TOWN AND COUNTRY PLANNING ACT 1990

FULL

Reference:	H16-1057-24	Date of Decision:	27th January 2025
Applicant:	Mr D Needham 8 Sandringham Walk Spalding Lincolnshire PE11 2RS		
Location:	Rear Of 8 Sandringham Walk Spalding Lincolnshire		
Description:	Erection of 1 Bed 1.5 storey dwelling

Drawing Name
Proposed Elevations

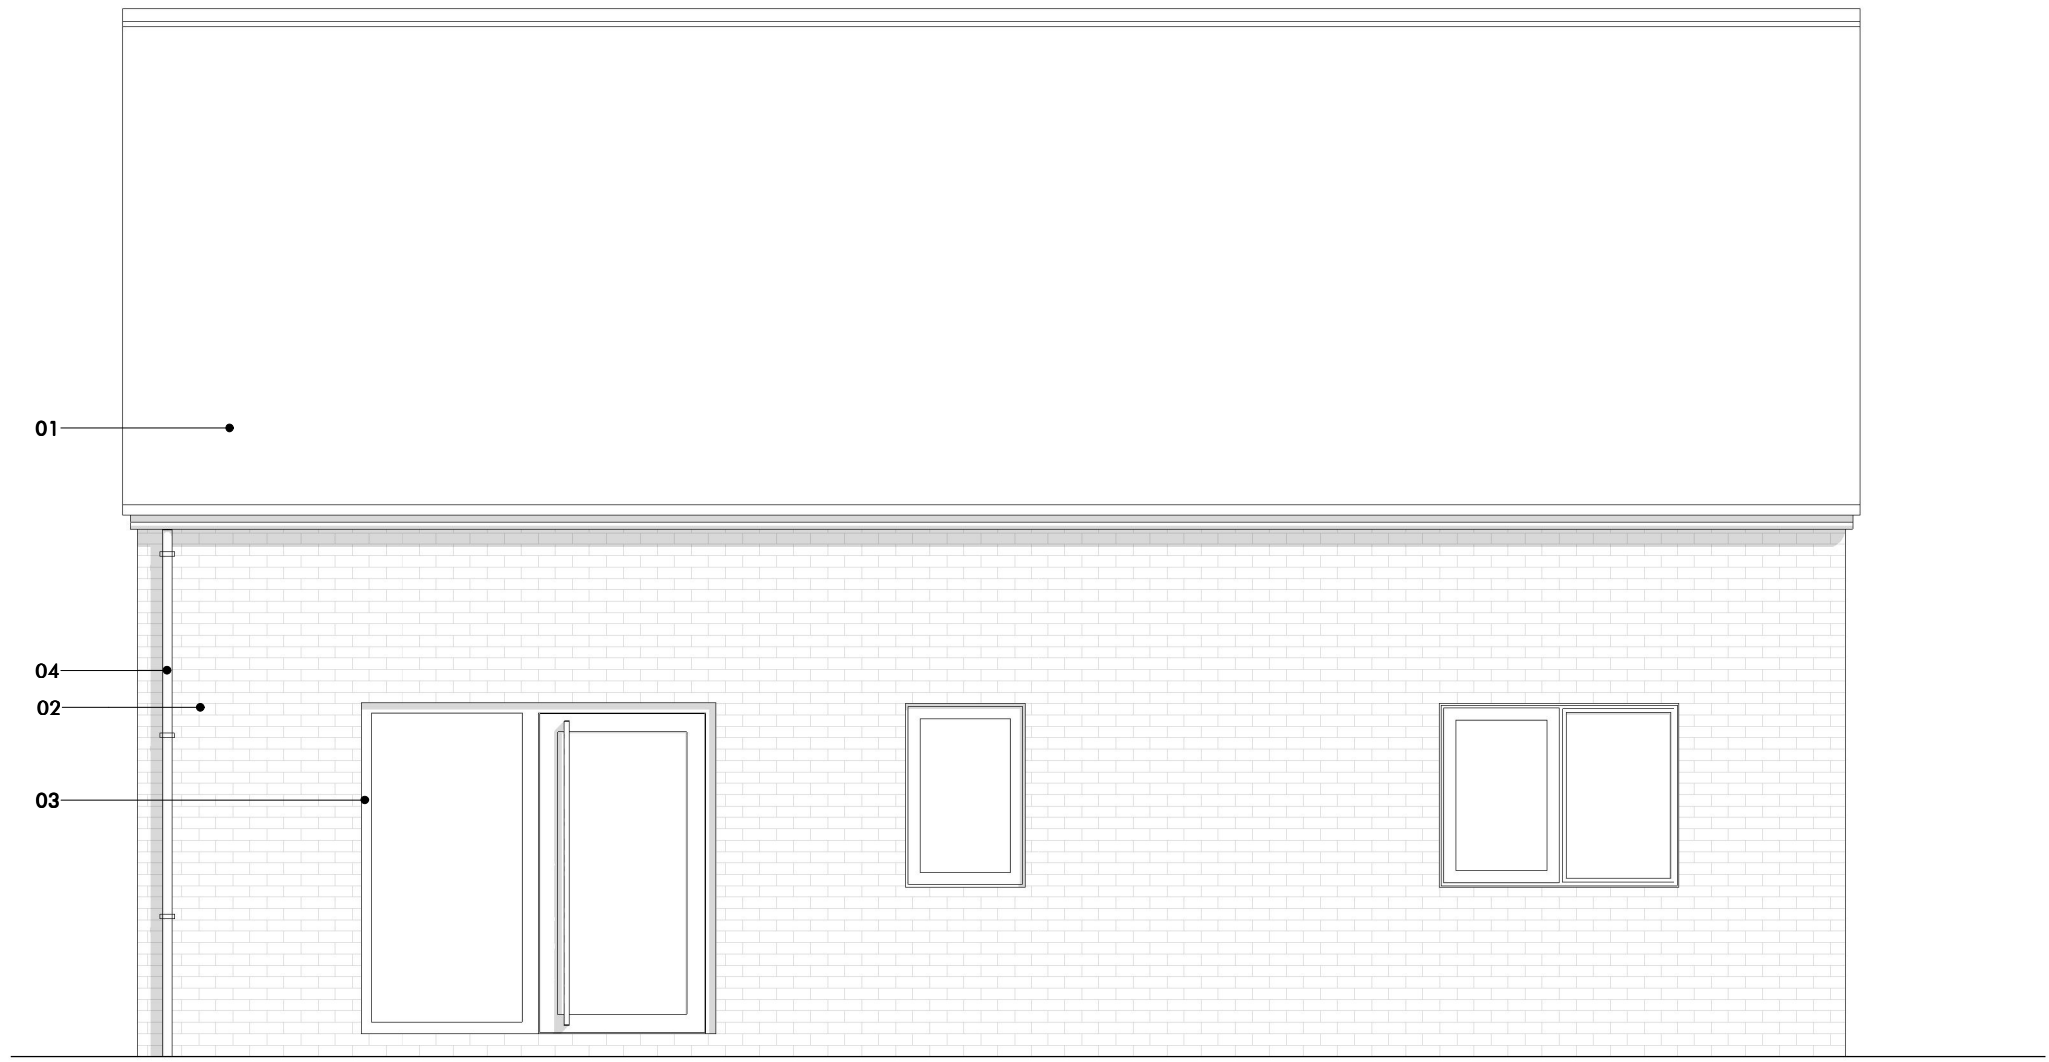
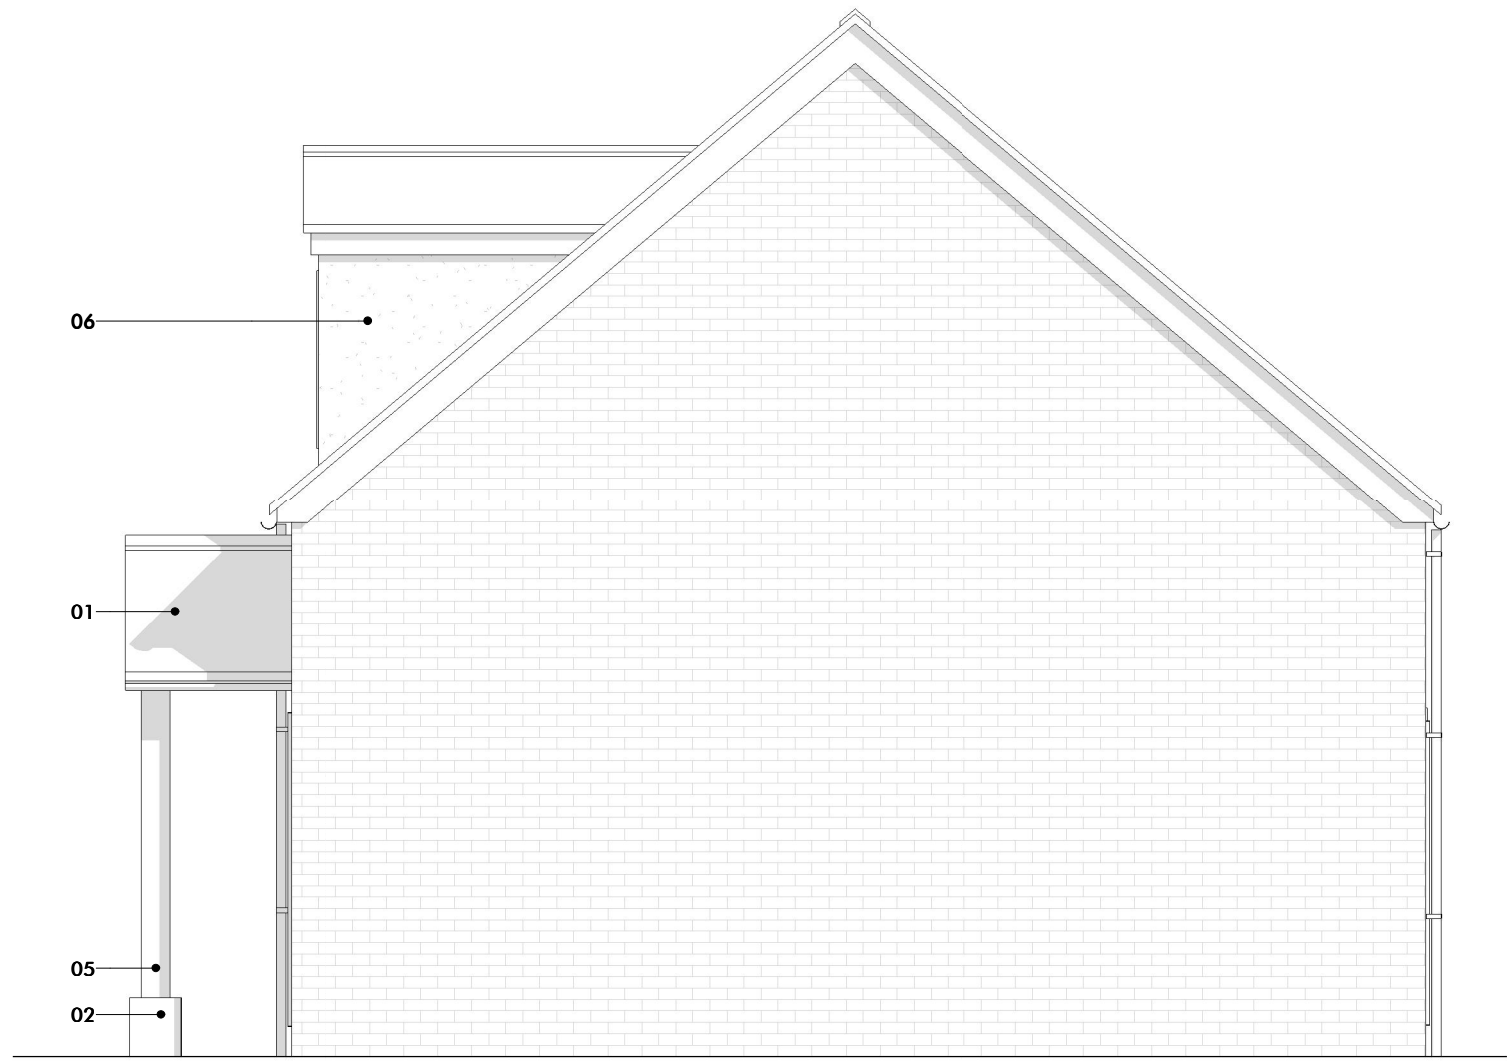
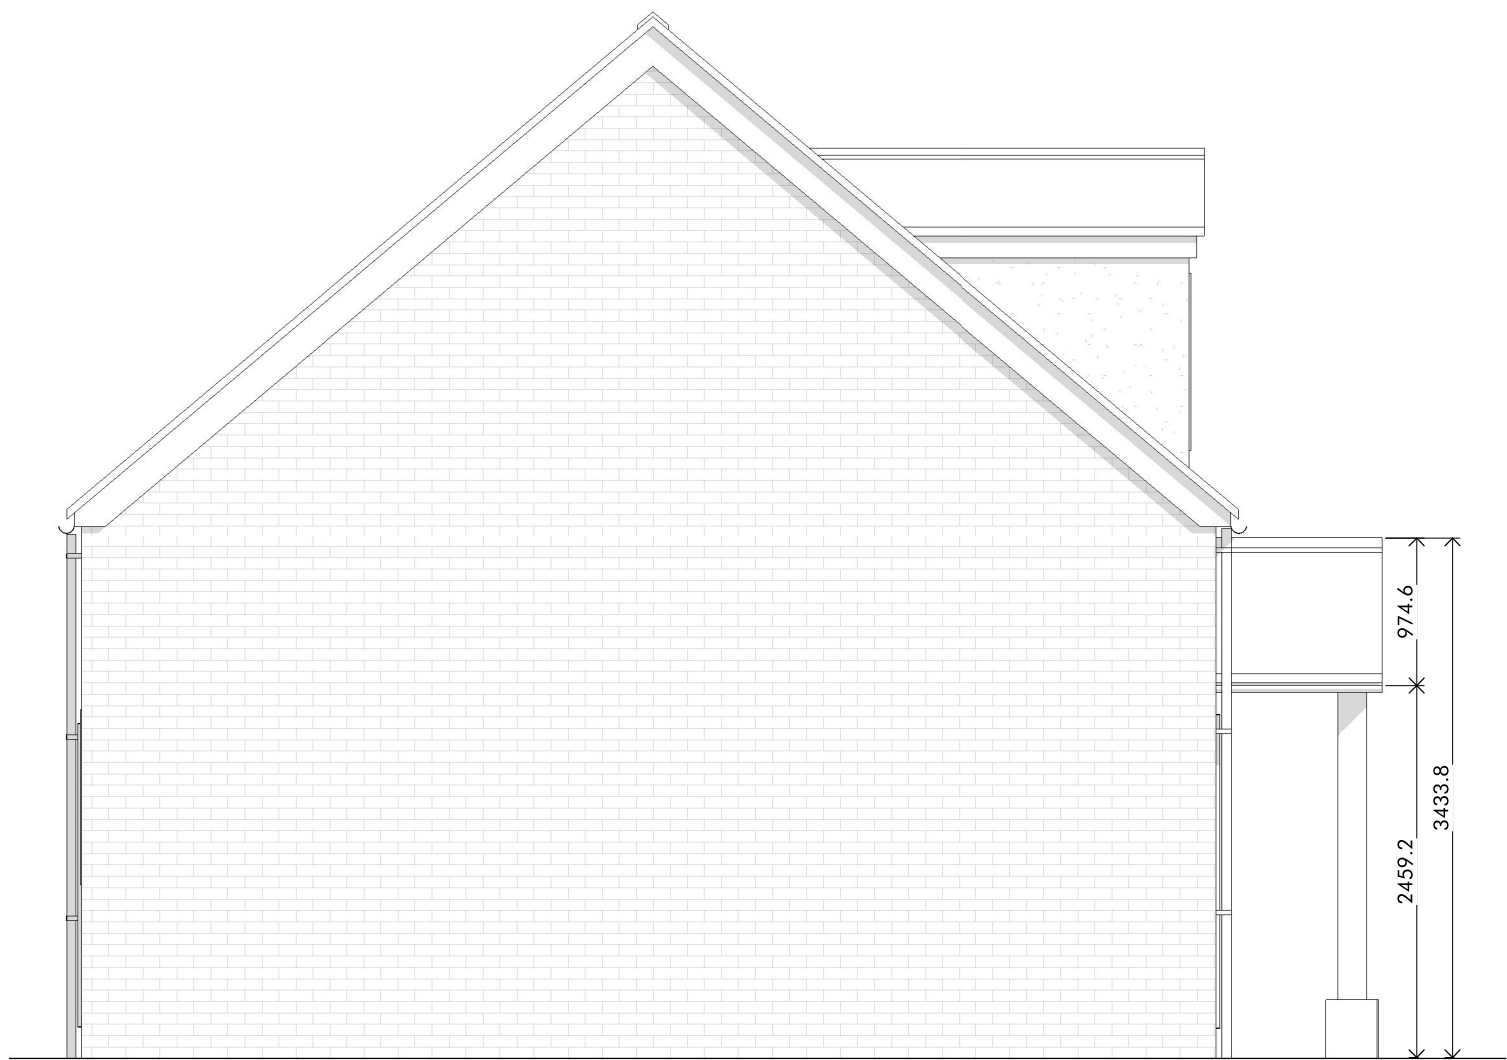
- 1 The proposal comprises a one and half storey dwelling which projects beyond a clear break in the build line. The proposal is considered to represent an incongruous form of development, out of keeping with the established built form of the area. The proposal is therefore considered to represent a harmful form of development, contrary to the provisions of the National Design Guide.
